Our Case Number: ABP-314942-22

Re: BusConnects Lucan to City Centre Core Bus Corridor Scheme
Lucan to Dublin City Centre

Re Planning application by NTA, Lucan to City Centre
Bus corridor. Observations for your consideration
Palmerstown
are

| Drawing File Name: BCIDA-ACM-GEO_GA-0006_XX_00-DR-CR-0014 | Sheet Number: 14 of 31 | Status: A | Rev: M01 |

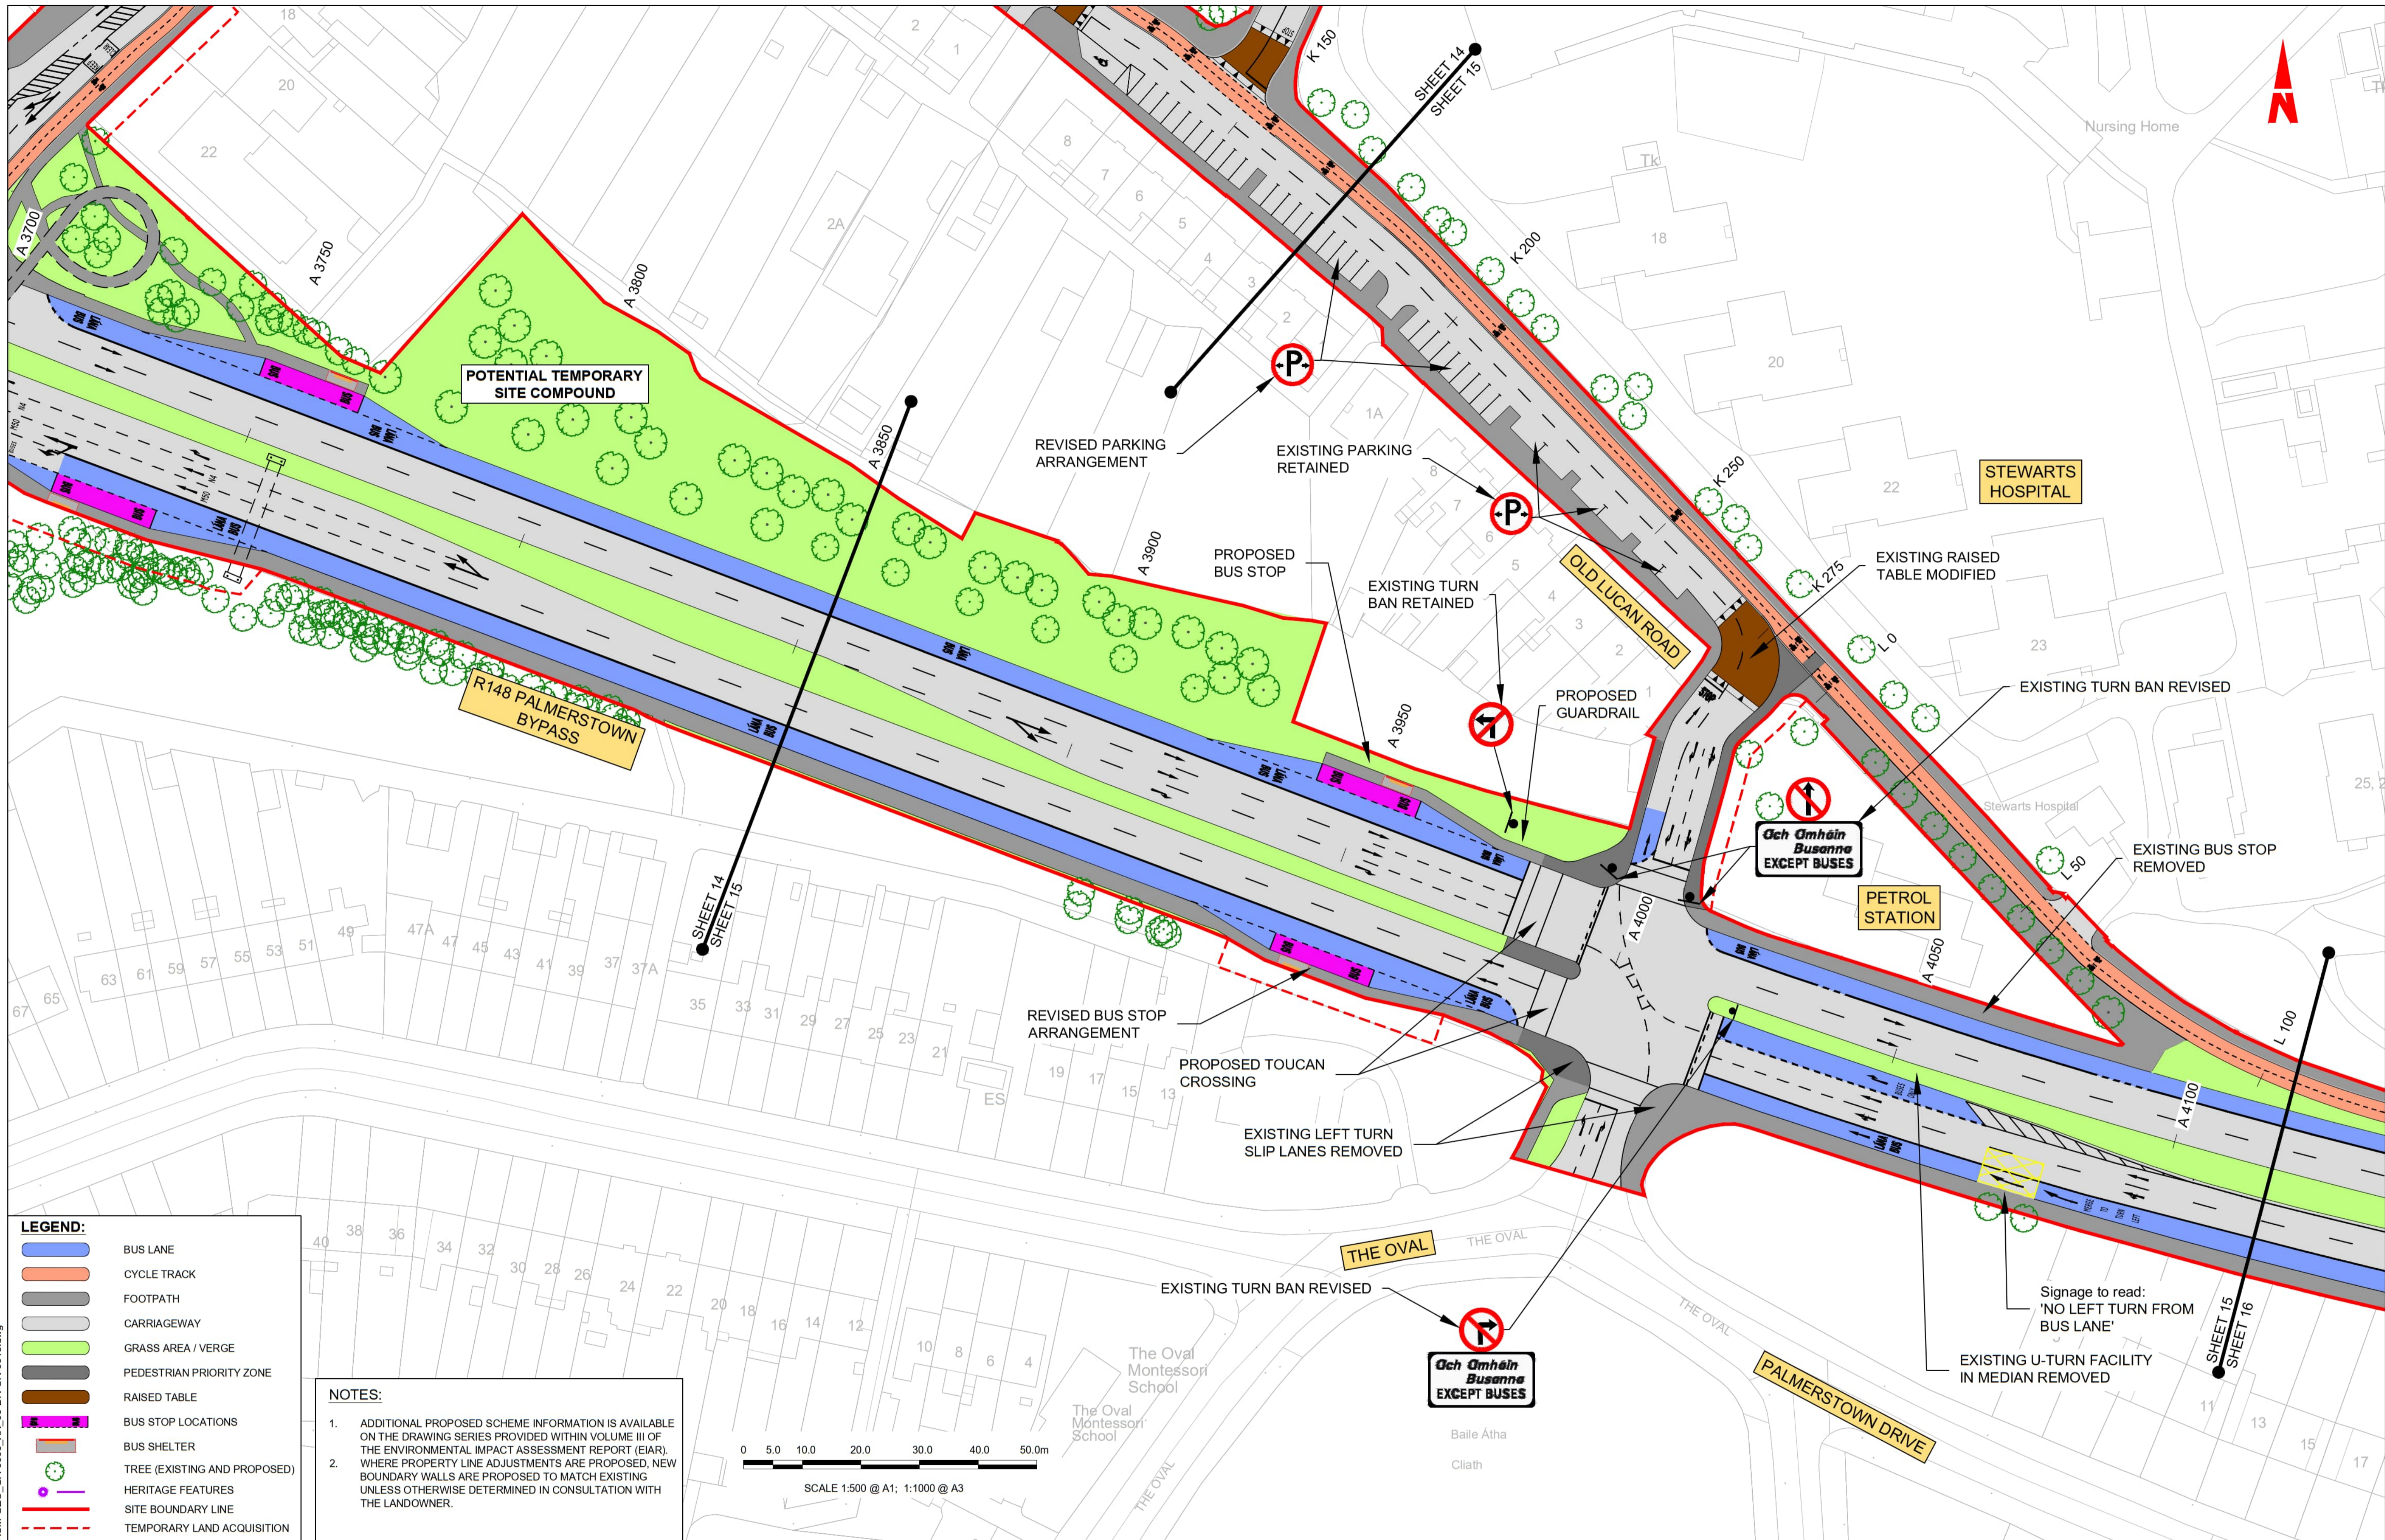
- Existing left turn slip lanes removed
 - Kennelstort road upper
 - Kennelstort road lower - 14 of 31

Effects Possible from removed slip lanes -
Congestion of traffic into both
residential areas in turn causing
a particularly high volume of
environmental impacts such as
emissions, air quality and pollution.

3. Restricted visibility at Junctions and property entrances

- effected individuals cyclists, pedestrians and those with mobility impairment with crossing the junction from both intersections
1. Kennelsport section
 2. The Oval section.

Result: Reasonable worse case consequence if in event did occur would be fatal or at Best serious injury

| Drawing File Name BCIDA-ACM-GEO_GA-0006_XX_00-DR-CR-0015 | Sheet Number 15 of 31 | Status A | Rev M01 |

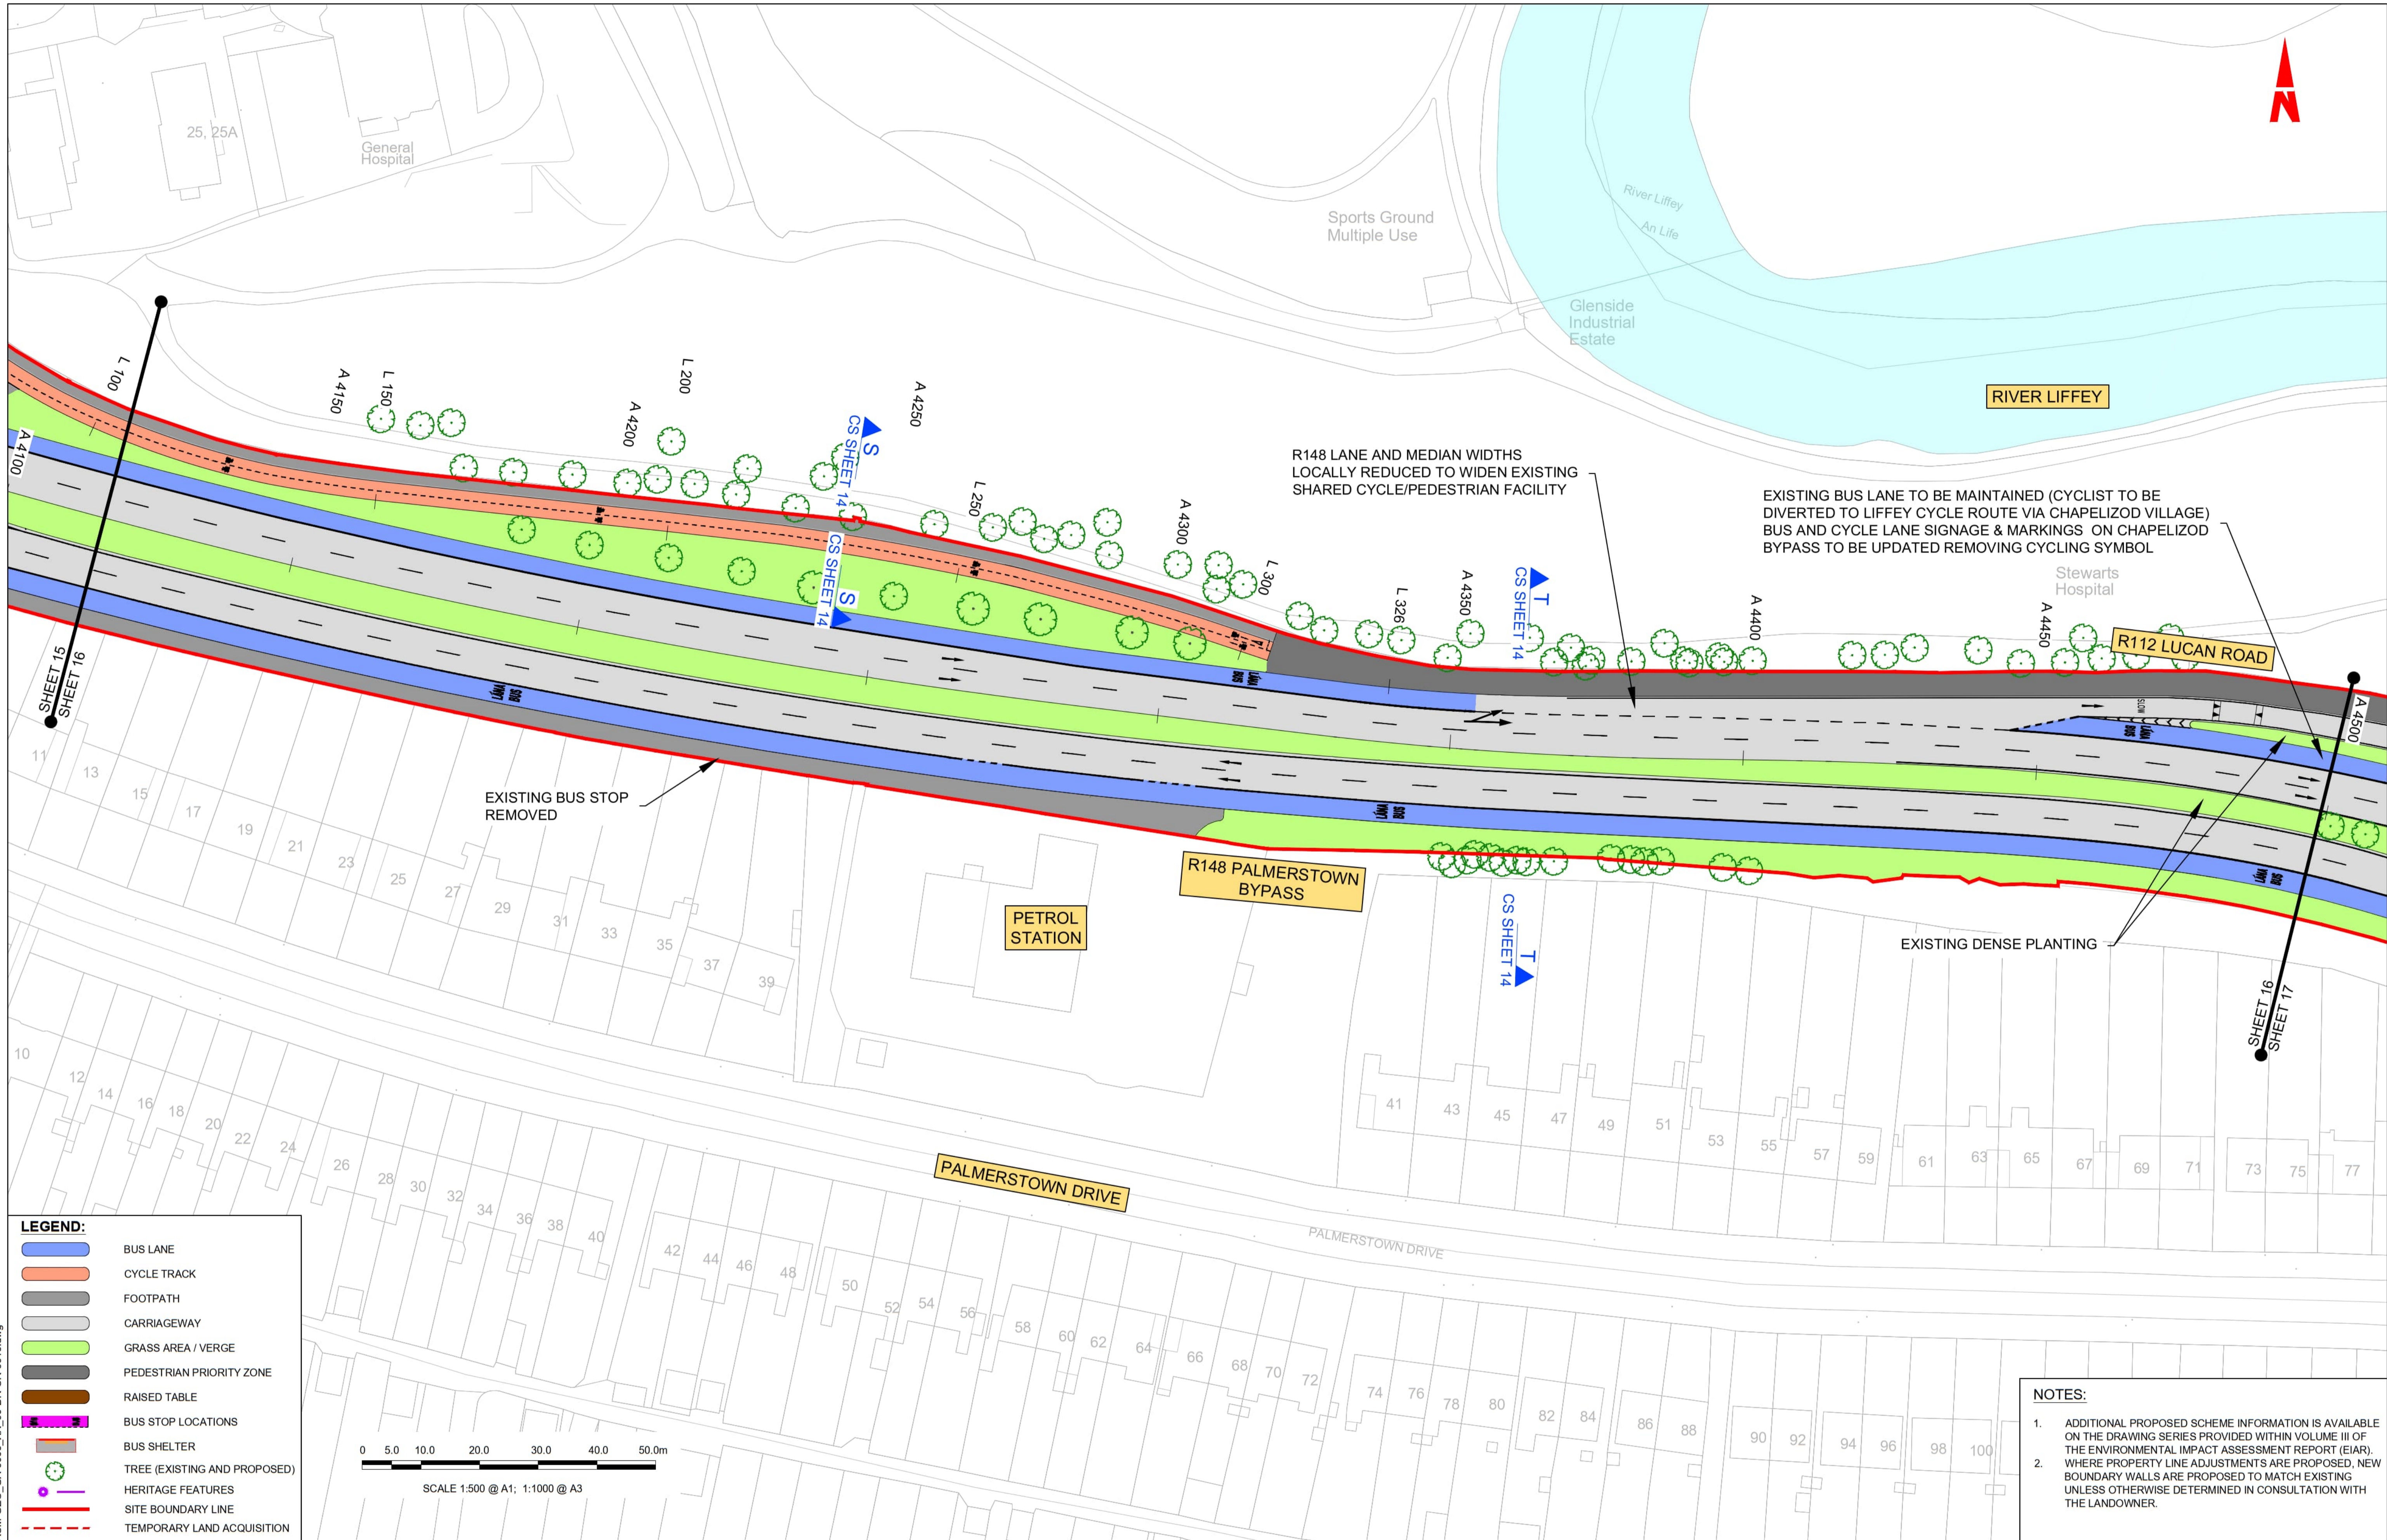
- Existing left turn slip lanes removed.
 - on leaving the oval to enter the R148
Palmerstown Bypass.
 - on entering the oval off the R148
Palmerstown Bypass.

Effects Possible from removal of slip lanes -
Congestion of traffic into both residential
Estates in the oval, which currently at least
of oval 3 schools, this causing a particular high
volume of environmental impacts on members of
public i.e. school age children. Such as air pollution.
